DEVELOPMENT REVIEW BOARD
SUPPLEMENTAL SUBMITTAL

PROJECT NO. PR-2021-004038
Application No. SD-2021-00098

RE: DRB Project Number : 2021-004038
Lots 3 - 6, Block 8, Broad Acres Subdivision
7521 Menaul Blvd. NE

SITE DEVELOPMENT PLANS FOR CHAMPION XPRESS
 NORTHWEST OF THE INTERSECTION OF MENAUL BOULEVARD N.E. & PENNSYLVANIA STREET N.E.
 LOT 3-6, BLOCK 8, BROAD ACRES SUBDIVISION
 CITY OF ALBUQUERQUE, BERNALILLO COUNTY, NEW MEXICO

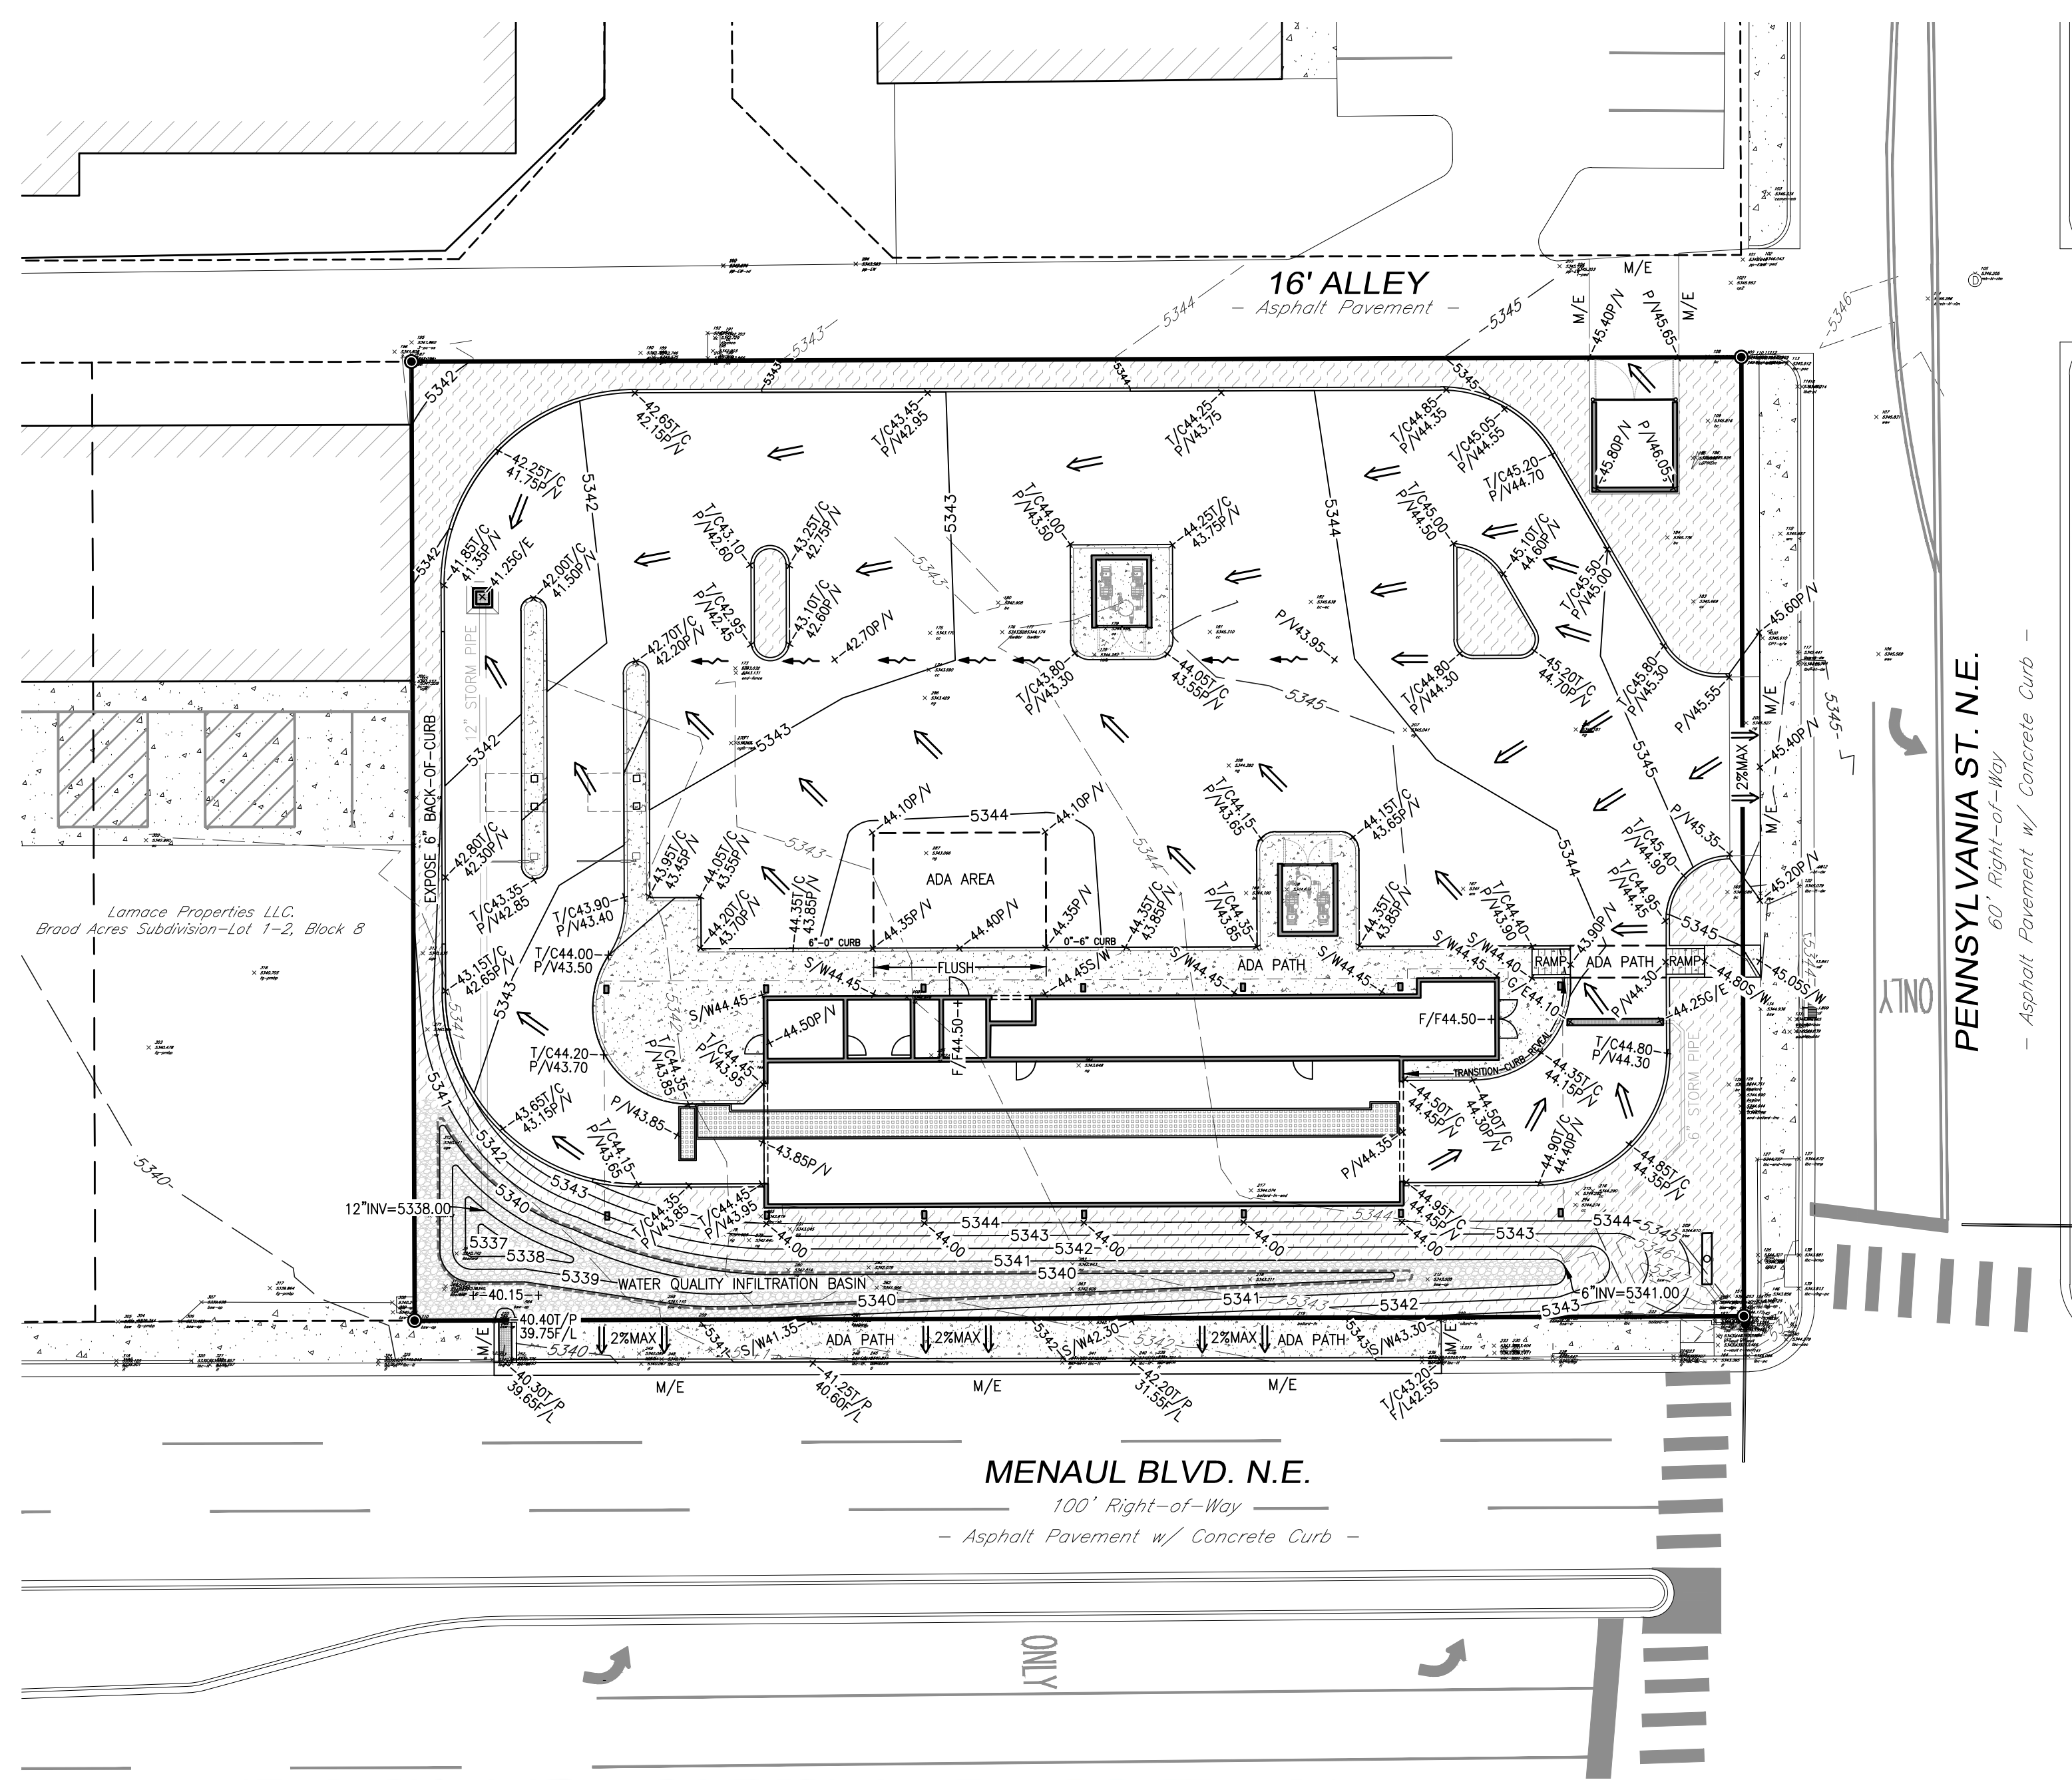
- Hydrology has no objection to the platting action.
Response: No Plat changes requested per drainage review.
- Comment – Site Plan – It appears that there is inadequate room for a trash truck to do a 90 degree turn in the alley between the two existing power poles. Please verify with Transportation on this issue. The trash enclosure may have to be rotated at a 45 degree to the alley instead for easy use. If this does get changed, then an updated Grading & Drainage Plan will be needed to submit to Hydrology. See photo below.

- Comment – Hydrology will need an revised Grading and Drainage Plan that reflects with work to be done within the alley and also showing the new location of the dumpster (if Transportation needs it adjusted).

Response: See response to Traffic Comment #4.
- Since the existing alley is in poor condition and that this site plans to use this and even place a concrete pad within the Public Alley, the entire alley along the northern property line will need to be brought to current City standards per drawing #2411.

Response: Updated Grading and Drainage Plans will be re-submitted due to alley improvements after DRB has approved and prior to building permit resubmittal.
